Subject: The Ashville House Plan
Harnett County

I reviewed the construction drawings and the truss and beam designs furnished by Comtech. Comtech also provided the reaction loads.

### Foundation Plan

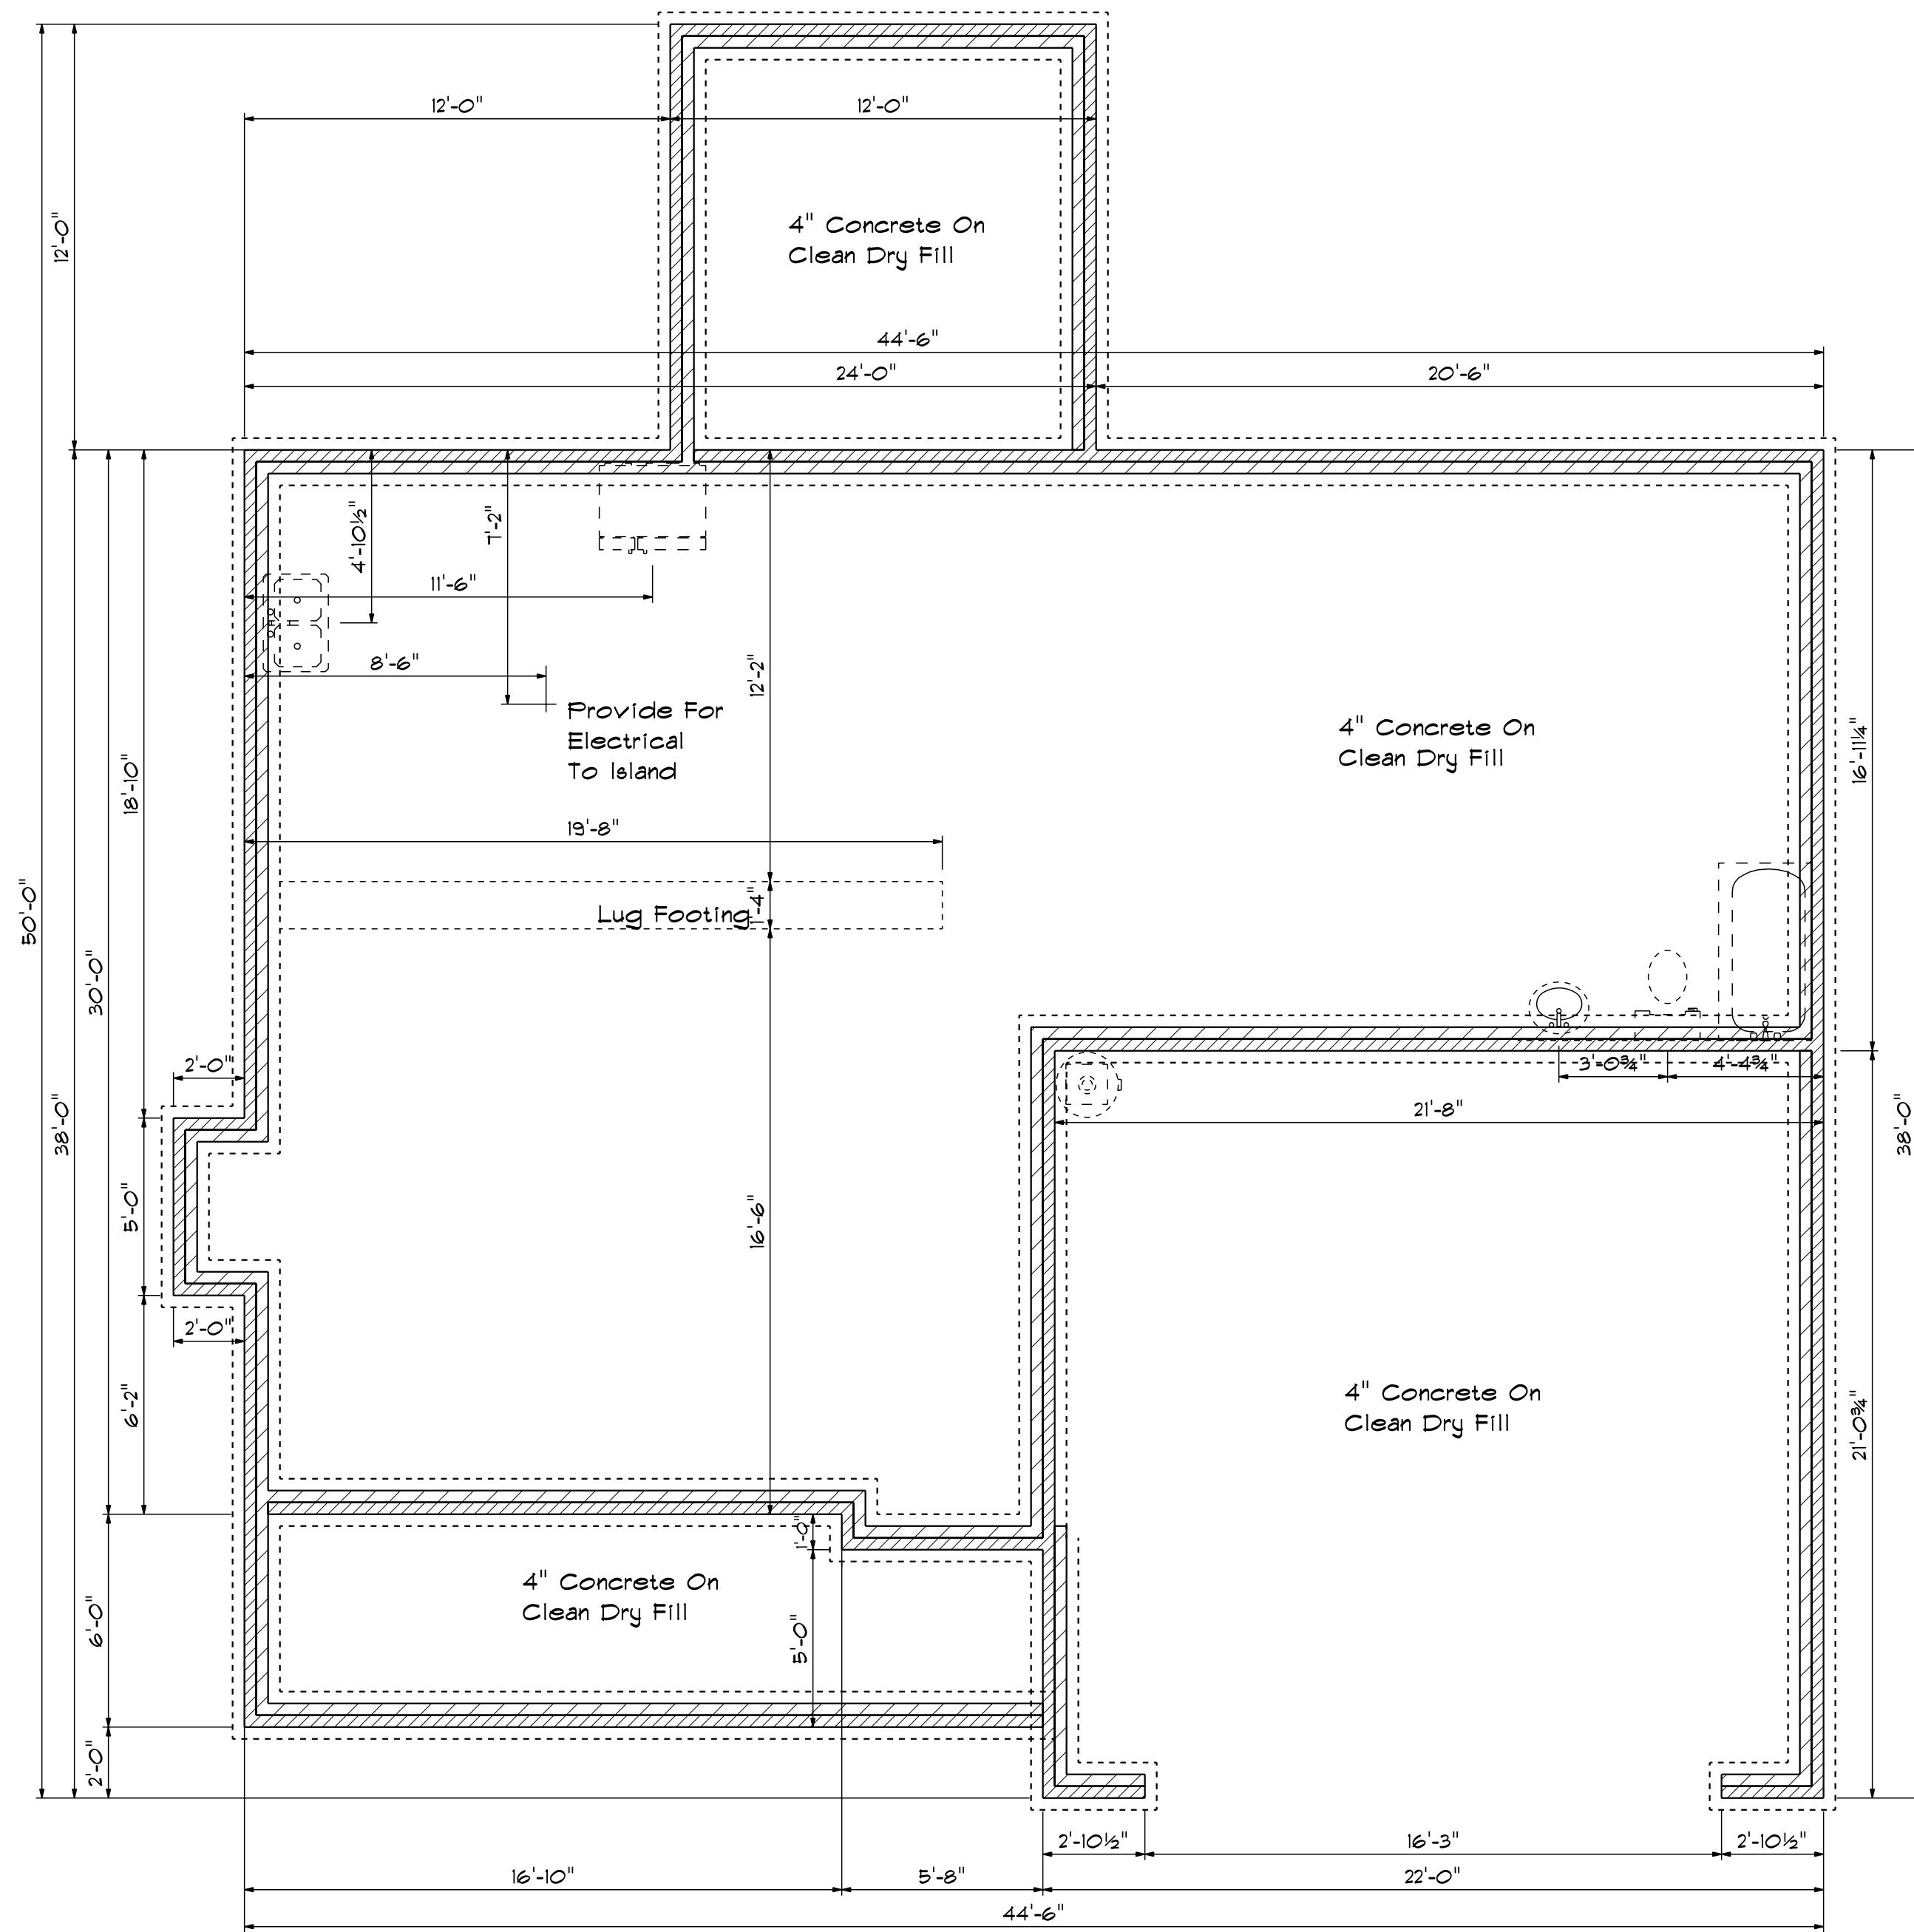
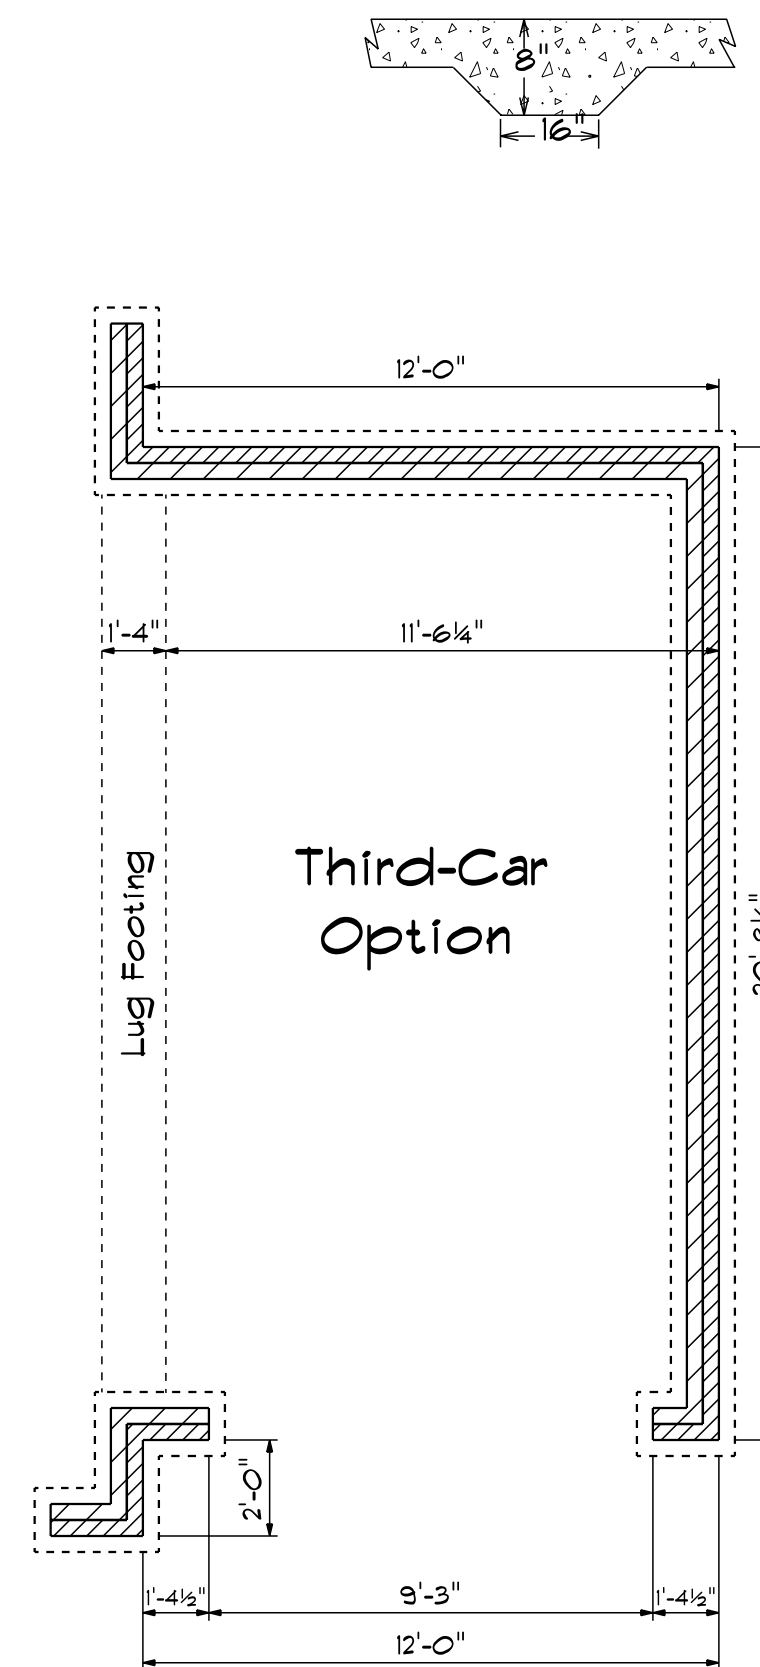
At the junction where trusses C1GR and B1GR meet, there is a significant load being transferred to the footing below. However, the 36" x 36" x 8" footing will support the load.
